**Southern
Water**

Our ref
DSA000011622

Proposal: Change of use from Class E (retail) / B8 storage to C3 residential and the creation of three dwelling units through the conversion of the rear of nos. 73 & 75 and the erection of a part single storey / part two storey rear extension with associated amenity space and refuse / recycling stores.

Site: BR/285/21/PL: - Rear of 73-75 Aldwick Road, Bognor, Regis, PO21 2NW.

Component: Proposed Site Plan - Ground Floor

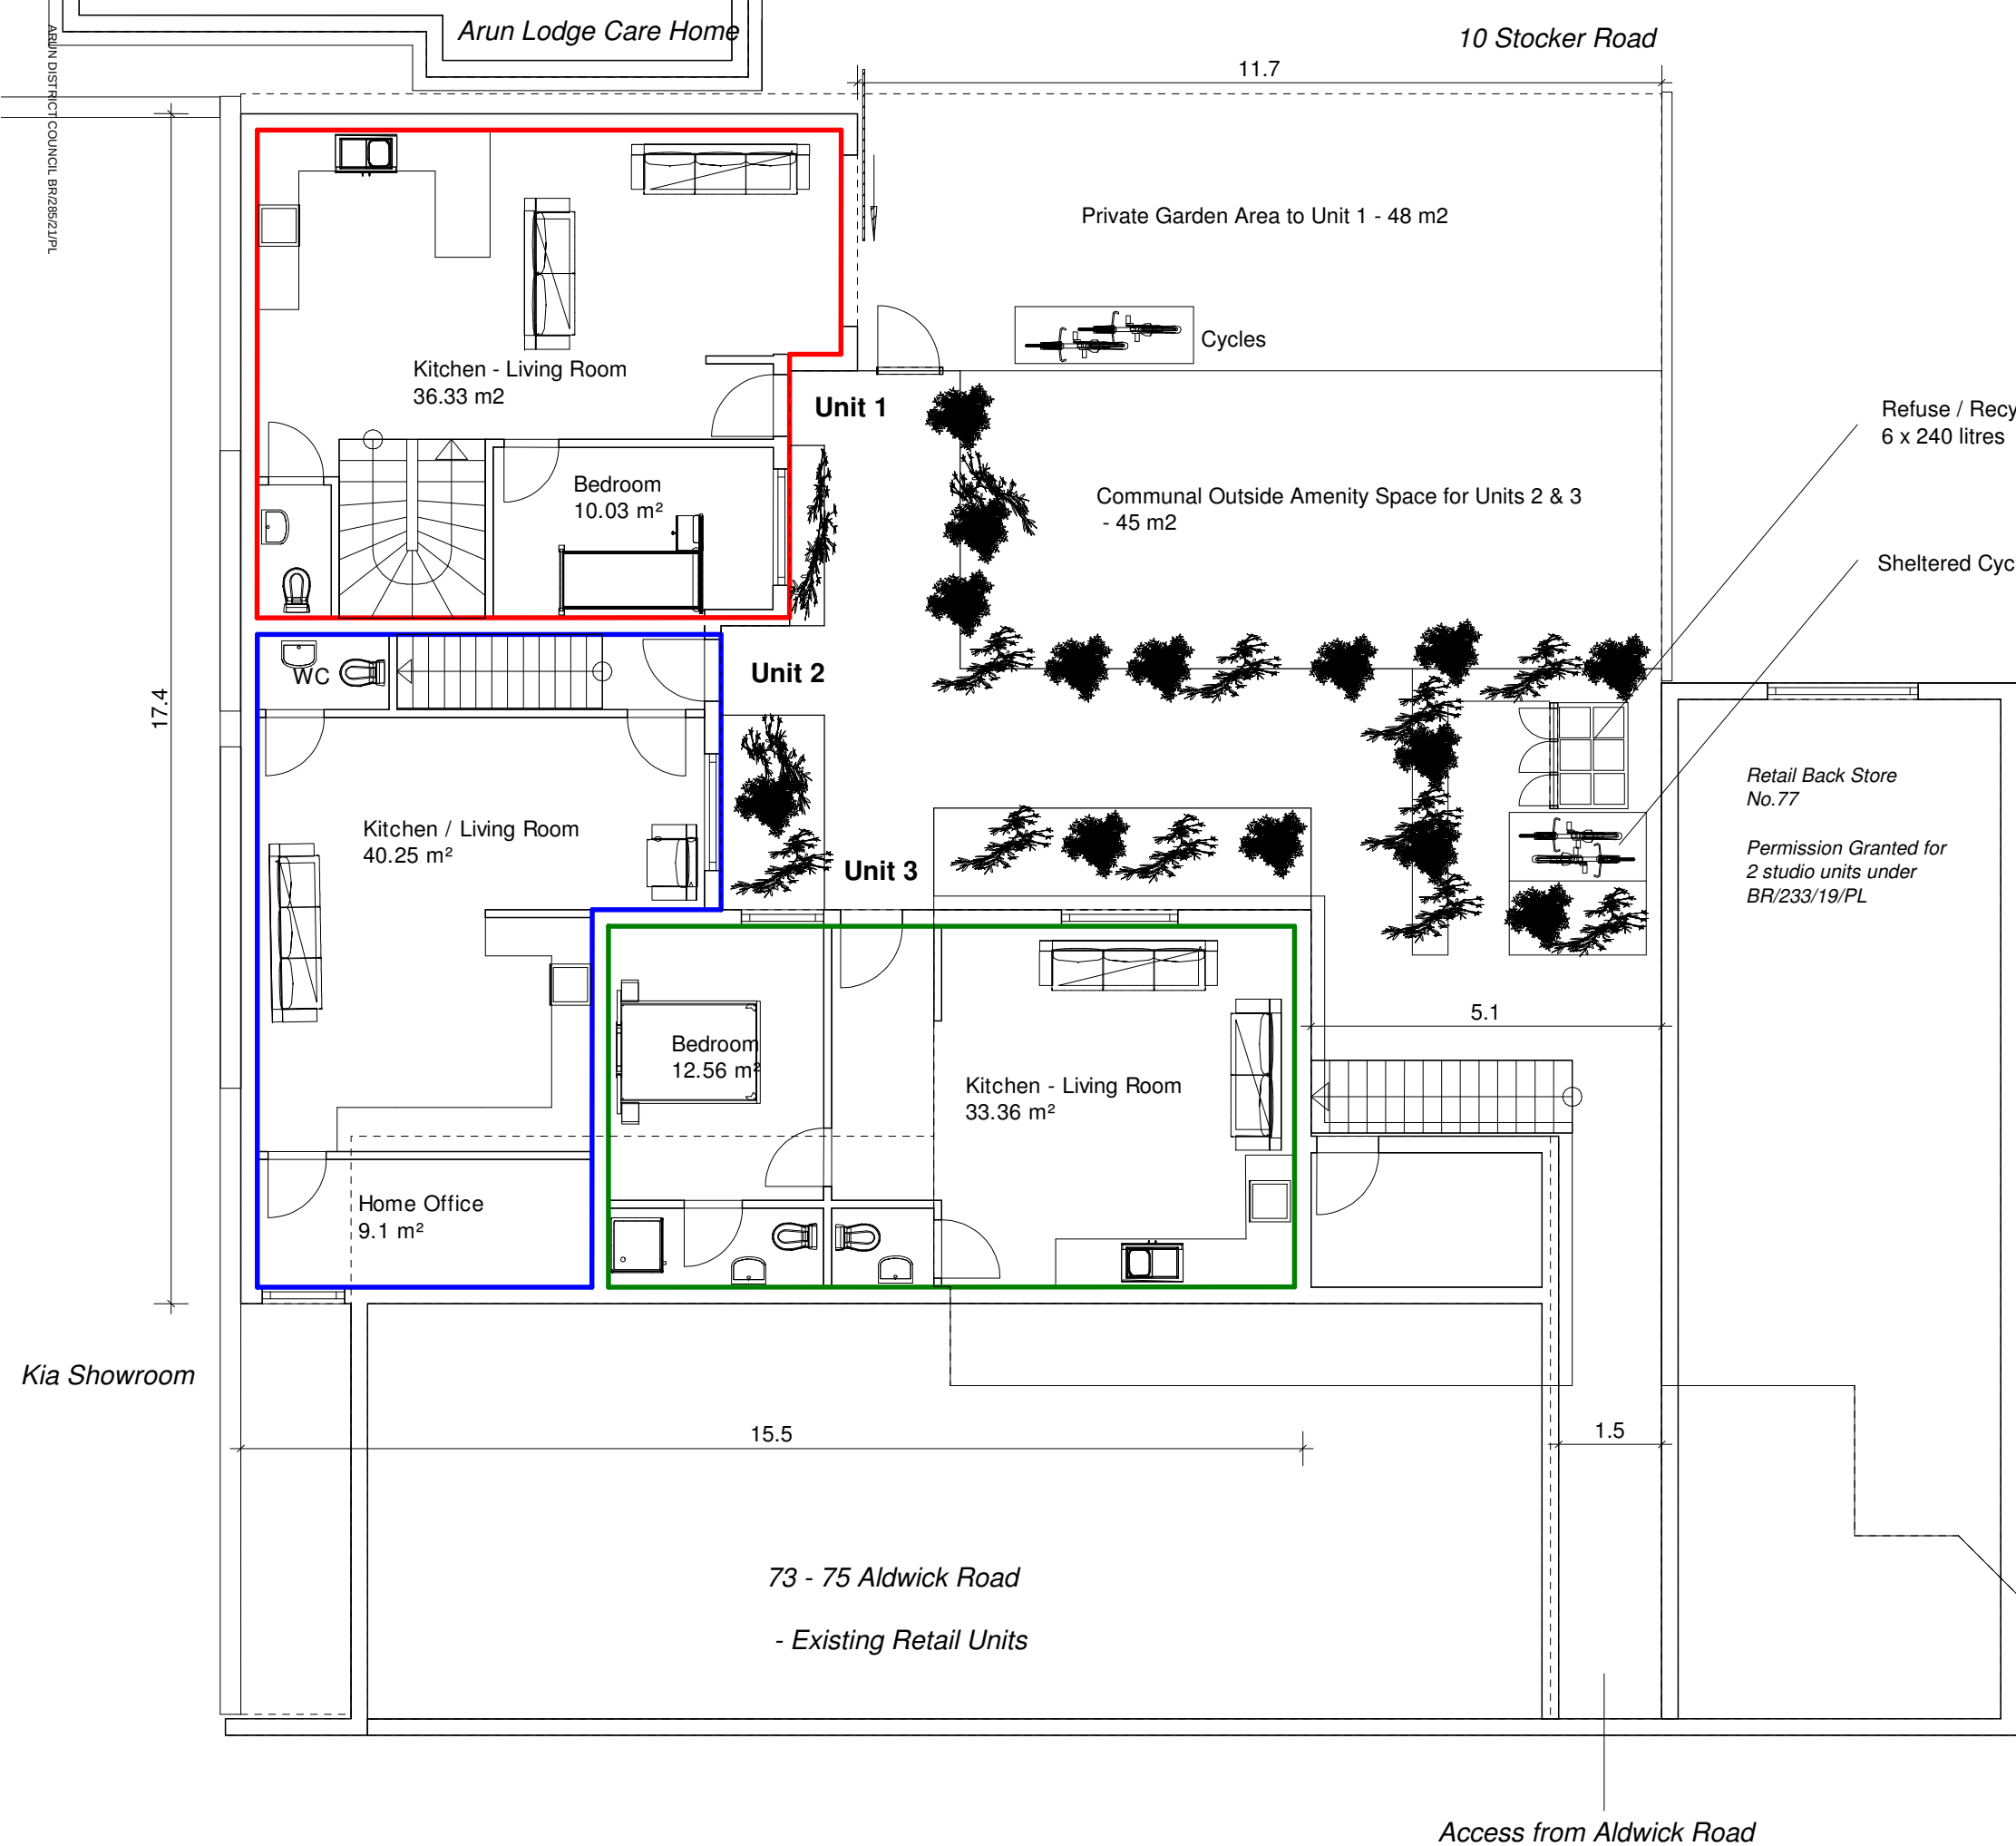
The attached plan shows that the proposed development will lie over an existing public foul sewer, which will not be acceptable to Southern Water. The exact position of the public apparatus must be determined on site by the applicant before the layout of the proposed development is finalised.

It might be possible to divert the sewer, so long as this would result in no unacceptable loss of hydraulic capacity, and the work was carried out at the developer's expense to the satisfaction of Southern Water under the relevant statutory provisions.

- The public foul sewer requires a clearance of 3 metres on either side of the gravity sewer to protect it from construction works and to allow for future maintenance access.
- No development or tree planting should be carried out within 3 metres of the external edge of the public gravity sewer without consent from Southern Water.
- No soakaways, swales, ponds, watercourses or any other surface water retaining or conveying features should be located within 5 metres of public or adoptable gravity sewer.
- All existing infrastructure should be protected during the course of construction works.

In order to protect drainage apparatus, Southern Water requests that if consent is granted, the following condition is attached to the planning permission; The developer must advise the local authority (in consultation with Southern Water) of the measures which will be undertaken to divert the public sewers, prior to the commencement of the development.
